Application No: AW/38/21/HH
Site Address: 4 St Richards Drive Aldwick PO21 3BH
Description of works: Single storey rear infill extension, first floor side/rear extension, conversion of garage to habitable use, porch canopy to front with pitched roof and alterations to fenestration

Thank you for your internet representation made on 2nd March 2021 which has been recorded as no objection with the comments as follows:

Sheet
Plans and Elevations as proposed

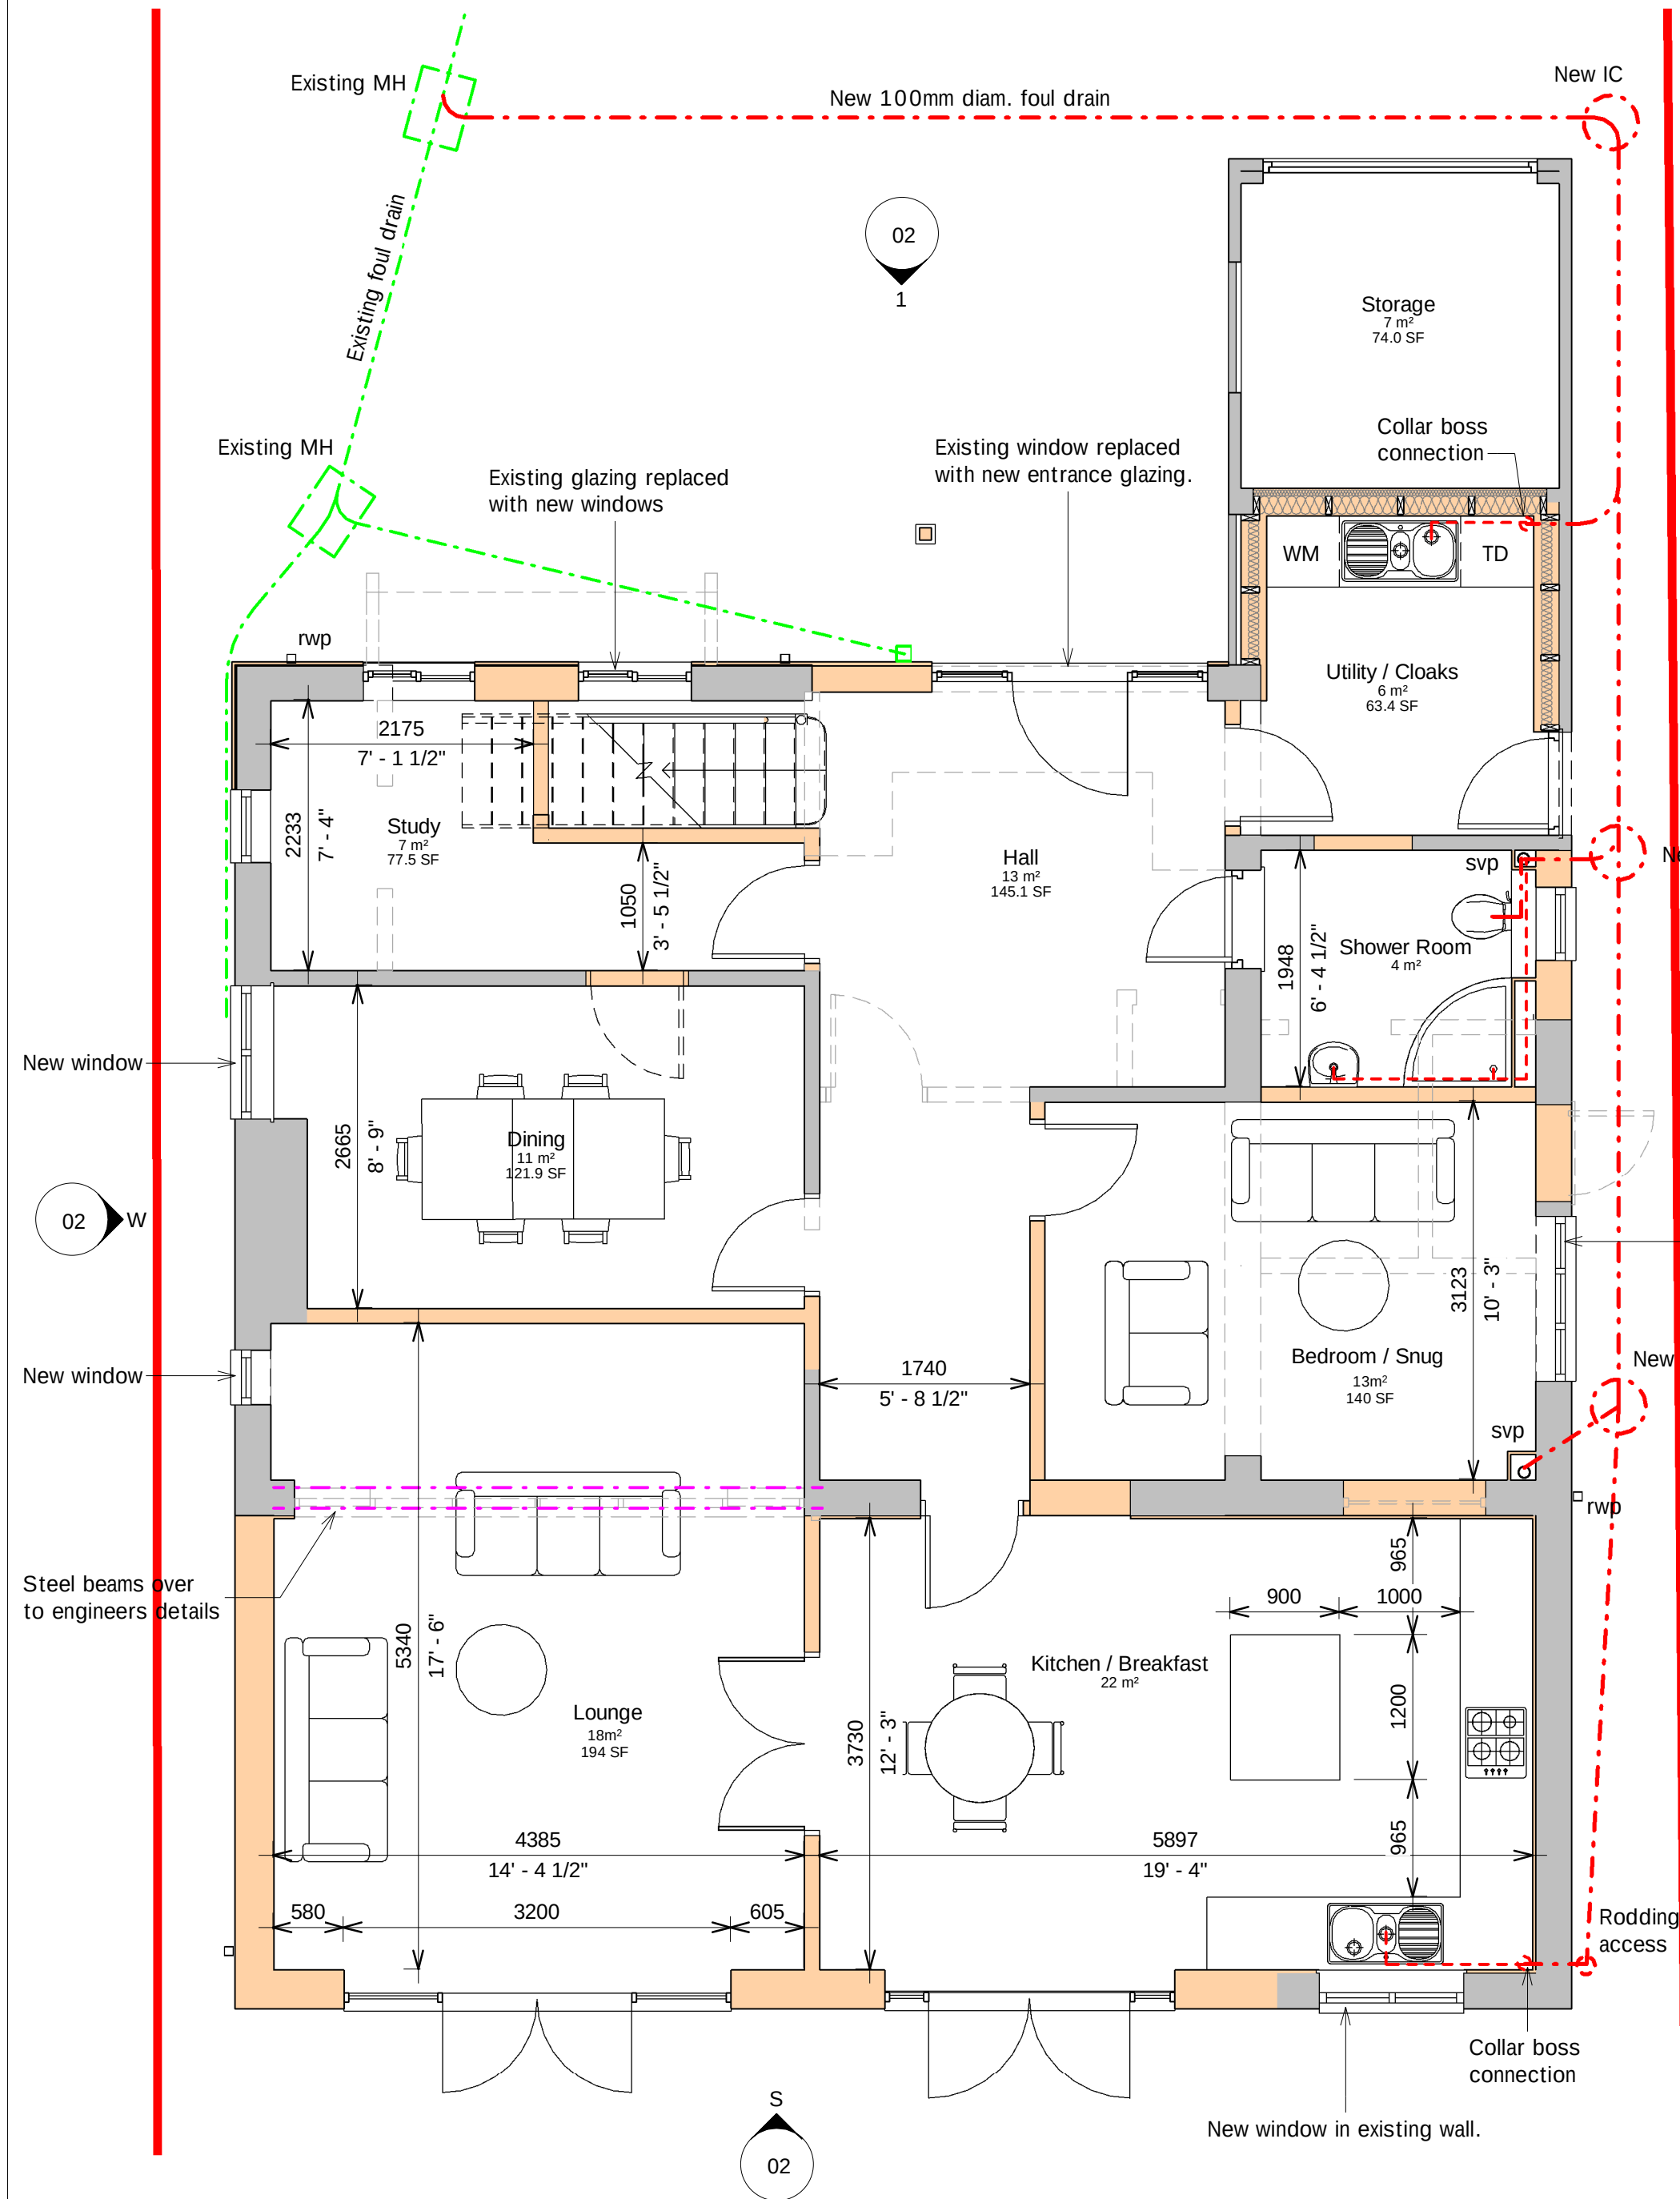
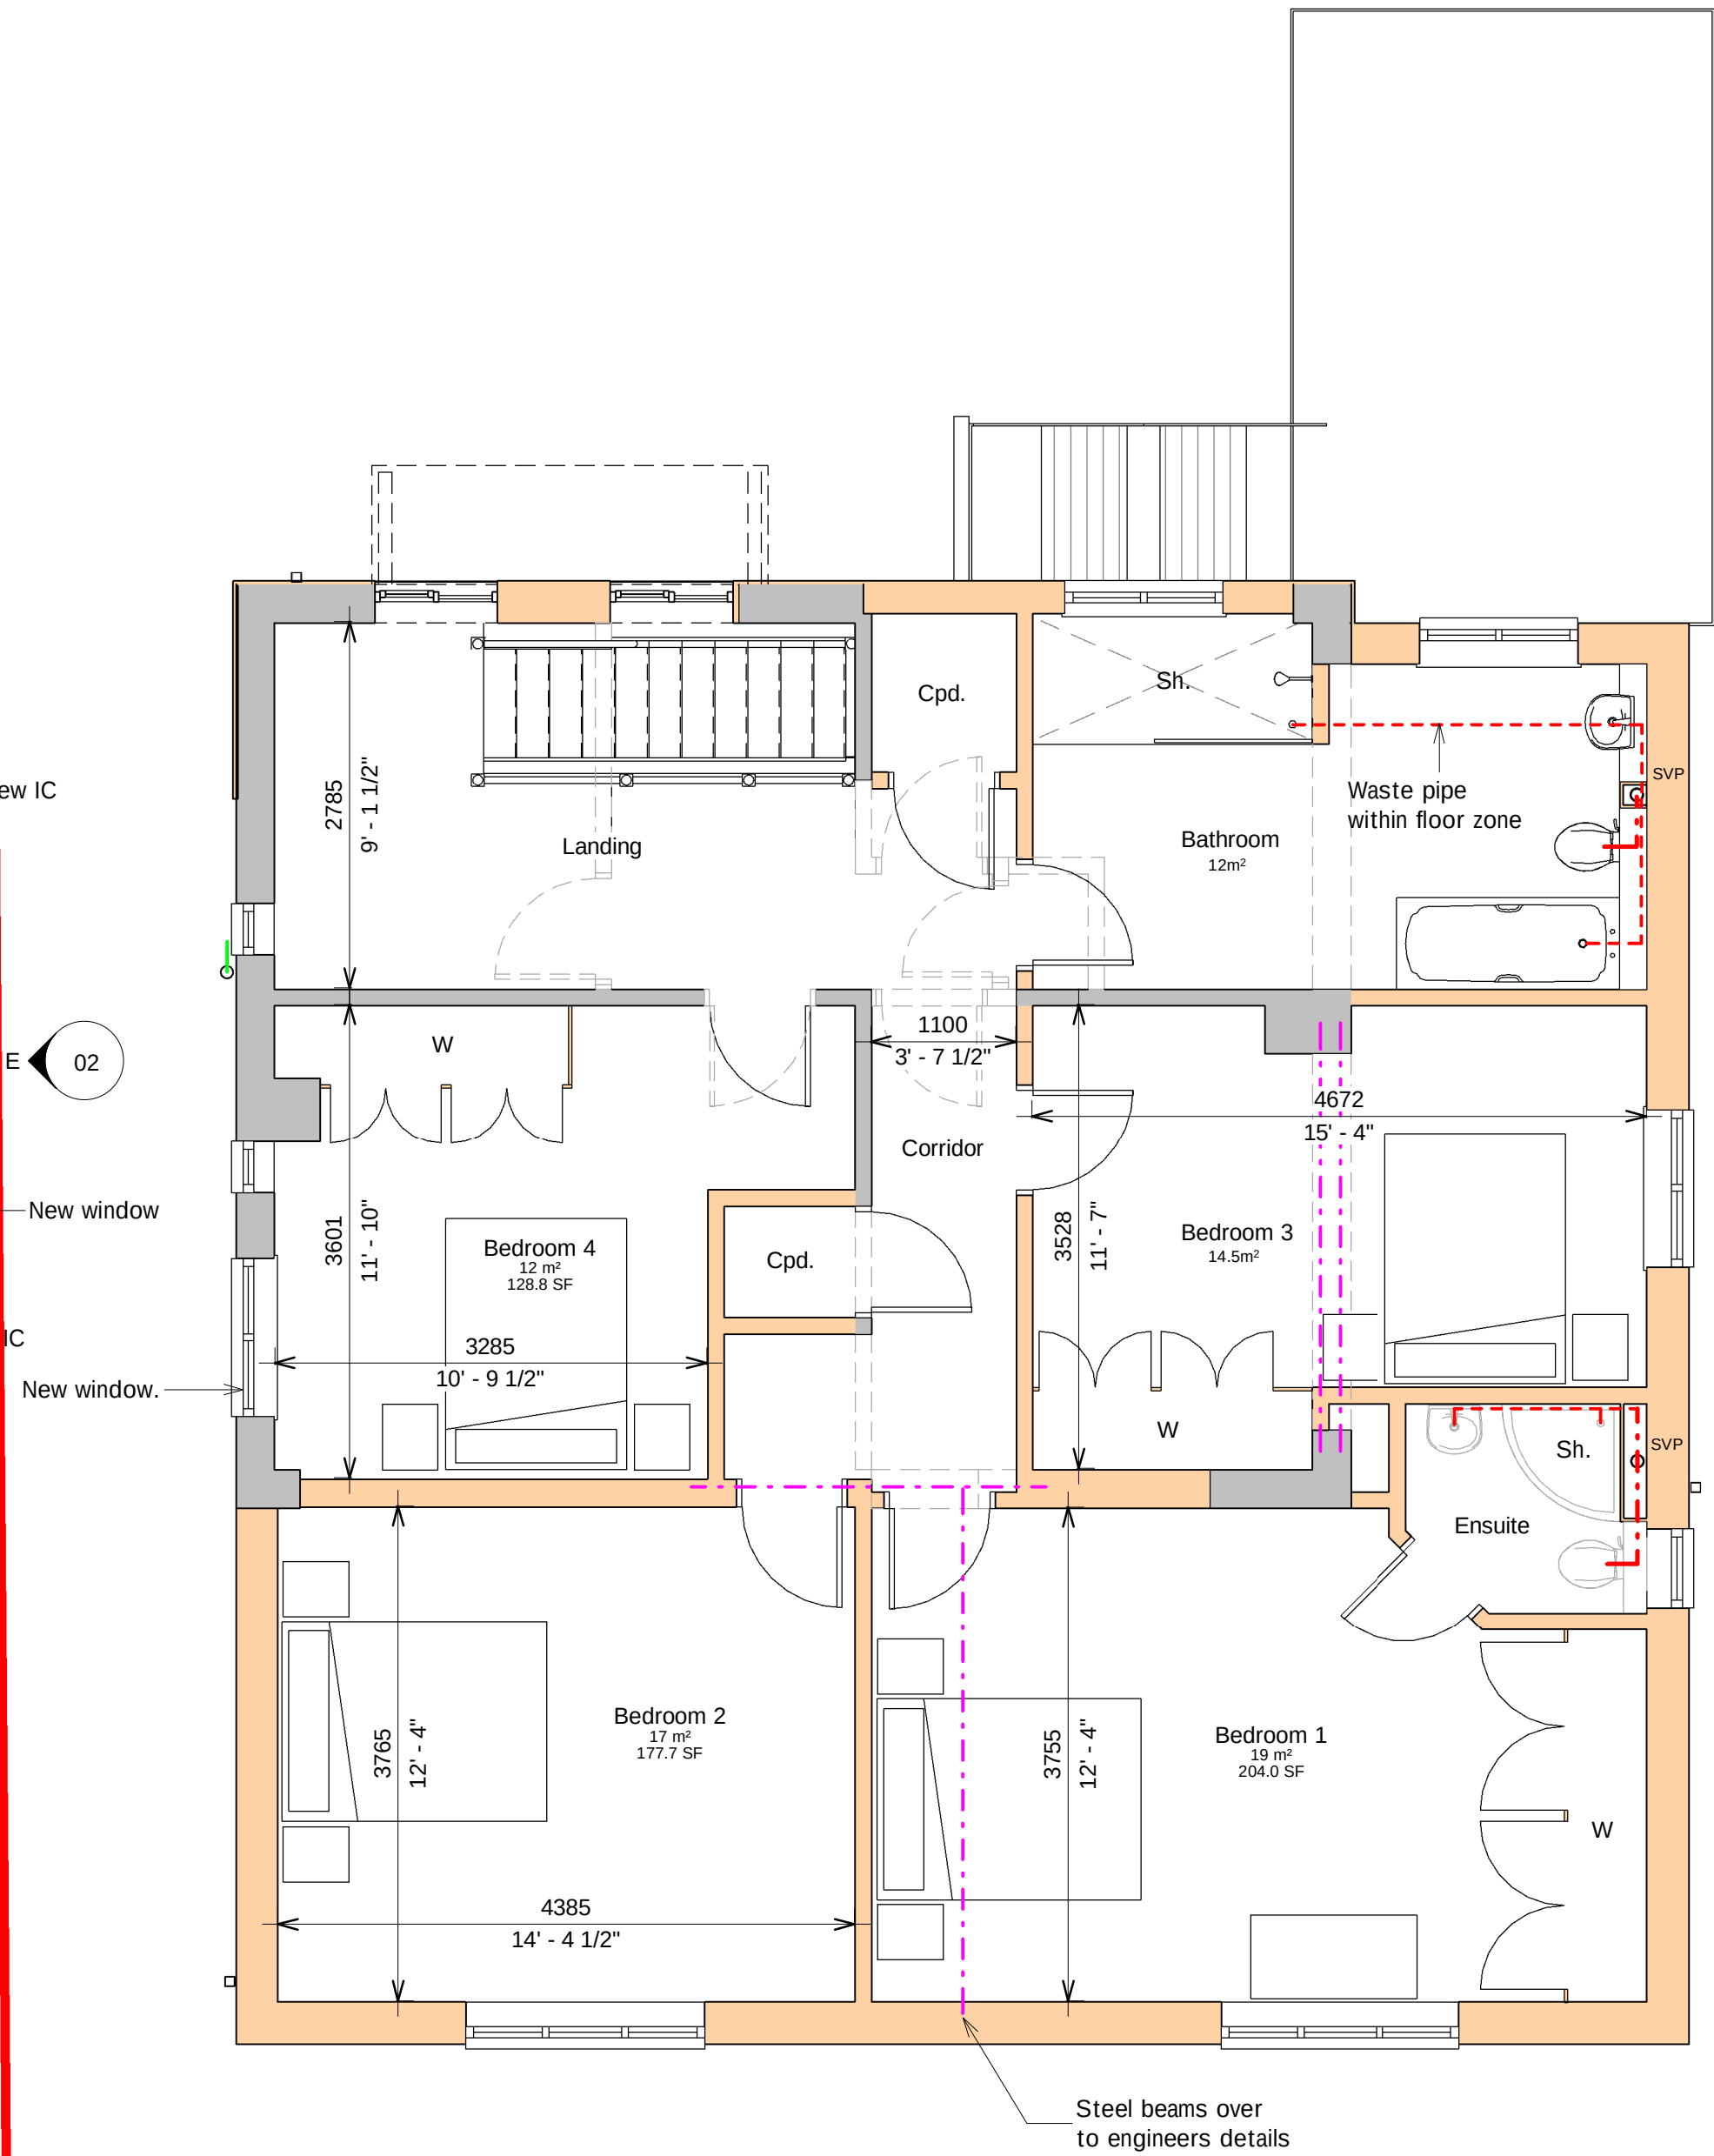
Members have no objection to the application, but they recommended that windows on the side aspects of the first floor should have obscure glass installed to avoid an overlooking effect on nearby rear gardens.
